**WEST SUSSEX COUNTY COUNCIL
STRATEGIC PLANNING CONSULTATION**

SUBJECT: AB/116/11/A- 2 x internally illuminated mounted menu/ poster boxes, 1 x internally illuminated mounted take away sign, 1 x externally illuminated projection sign & 1 x set of non-illuminated vertical text installed behind glazing.

Pizza Express, 33, High Street, Arundel, West Sussex, BN18 9AG

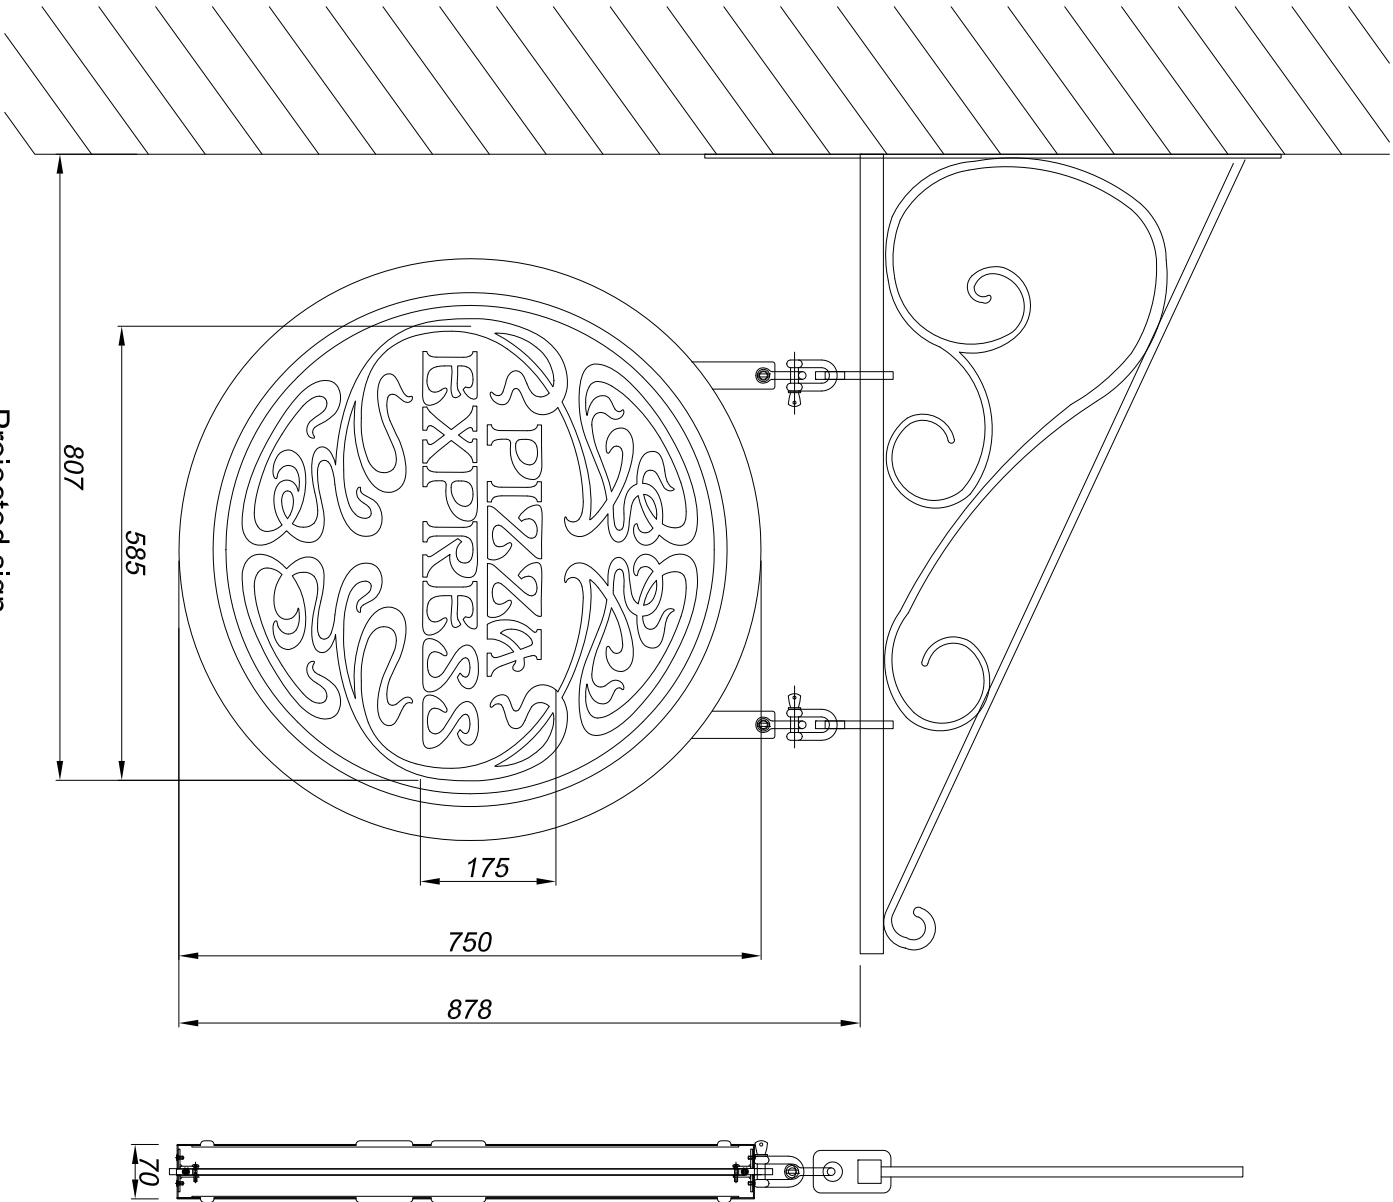
No concerns based on the proposed plans; as the sign 1 overhangs the pavement, a Highway license will be required before it is erected.

Before the commencement of any operation, the applicant is advised to contact West Sussex County Council (Tel no: 01243 642105) to obtain a Section 177 Licence under the Highways Act 1980 to cover any structure that overhangs the highway.
